Arun Parks & Landscapes response

Response to Planning Application

Description: Demolition of existing pavilion; erection of new Sports and Community Hub comprising of new 3G football pitch, improved turf pitches for football, multi-use games area, locally equipped play area, hub building, storage facility, car parking, EV charging points, access road, landscaping, associated works and infrastructure. This application is a Departure from the Development Plan and is in CIL Zone 3 (Zero Rated) as other development.

Location: Sports Pavilion Decoy Drive Angmering BN16 4DN

Appendix B: Post-Development Habitats Plan

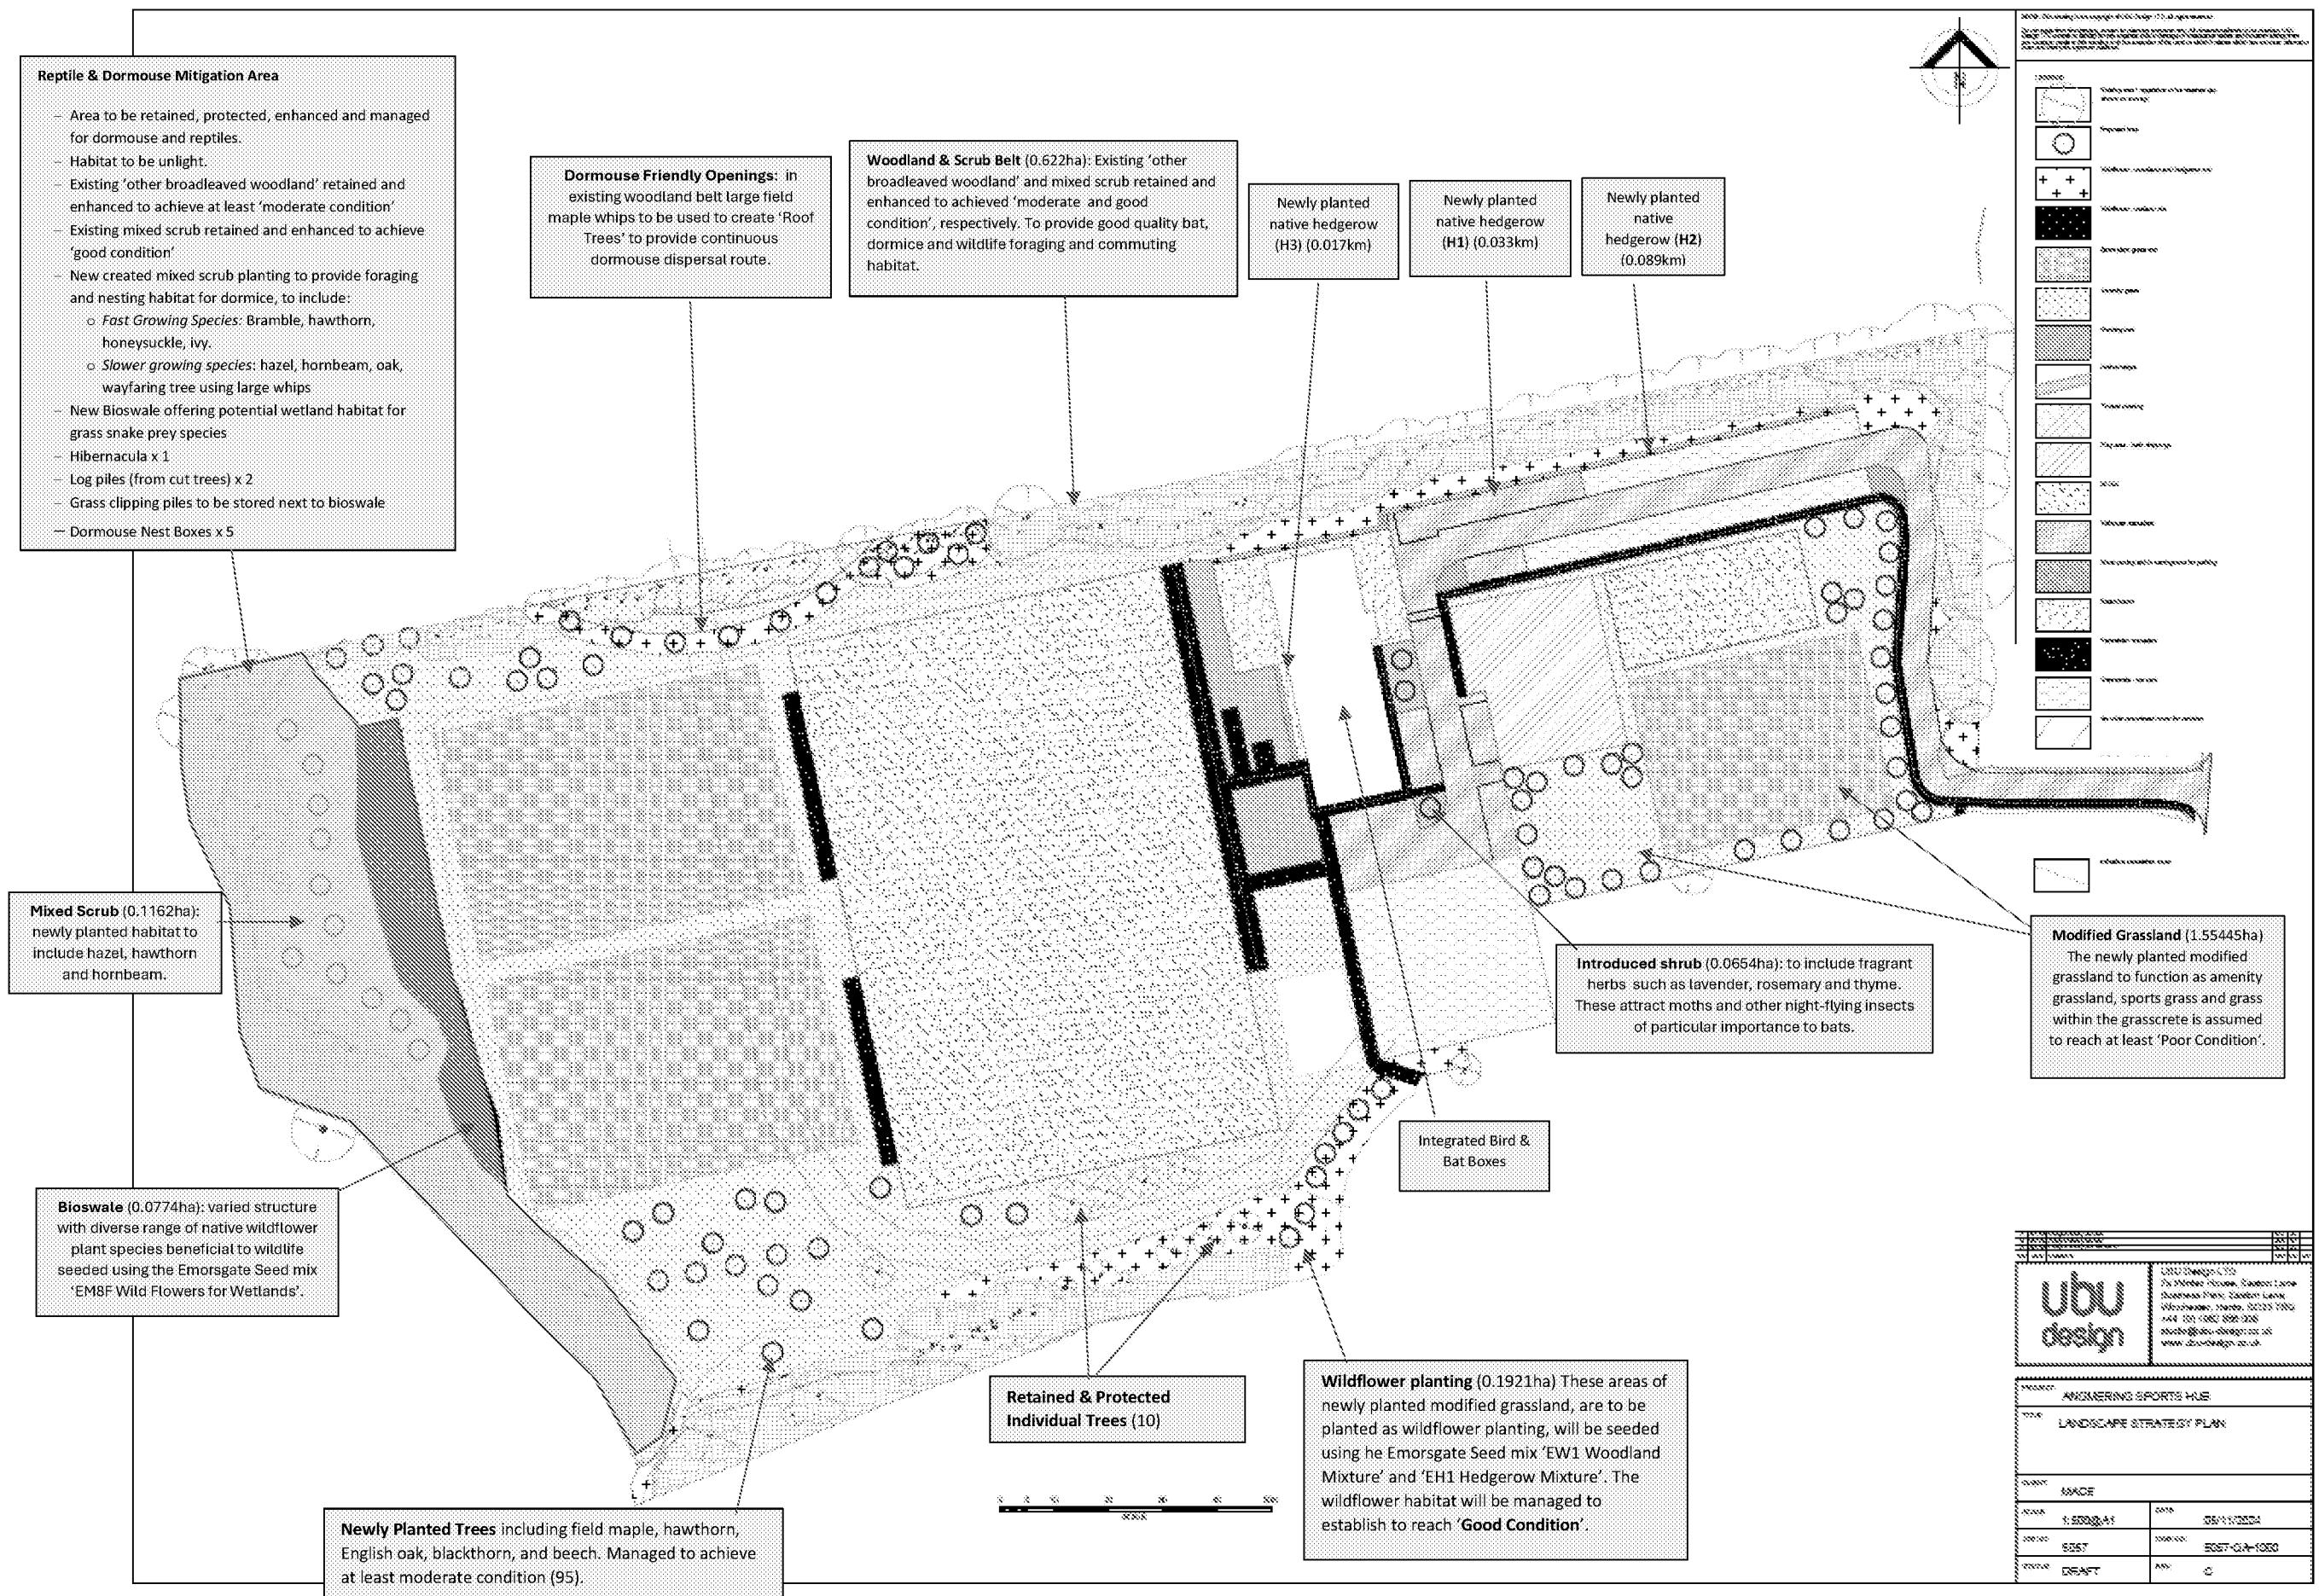
The soft landscaping as presently shown is largely indicative as shown within the Public Open Space site plan 5009 REVP02. Existing and to be retained green infrastructure has been shown along with proposed tree removals; which will be required to accommodate the southern end of the cricket pitch proposals. Detailed soft landscaping plans in line with screening and Biodiversity Net Gain (BNG) requirements will need to be submitted for approval proposing a comprehensive scheme to include native and ornamental species with a good range of species composition allowing for diversity across the site. Tree proposals (which appear presently sparse- but only indicative at this stage) will need to be selected for suitability to location and supplied at a size which will allow instant impact and form a well structured scheme. Soft landscape detail will need to be submitted in scaled plan form detailing species choice, quantities, planting densities and size at time of planting. A maintenance and management programme will also need to be submitted to ensure adequate provision to support establishment and ensure the scheme will thrive to maturity. Buffer zone planting areas need to be of suitable depth and species composition.

The existing green boundary evident in places will require further boundary planting treatment to enhance and improve.

A full and detailed landscape scheme will be required to be submitted for approval, detailing quantities, species choice, position, densities and size at time of planting. This should be plotted in plan and list form and in relation to the trees and vegetation to be retained so that a clear picture of the proposals can be seen.
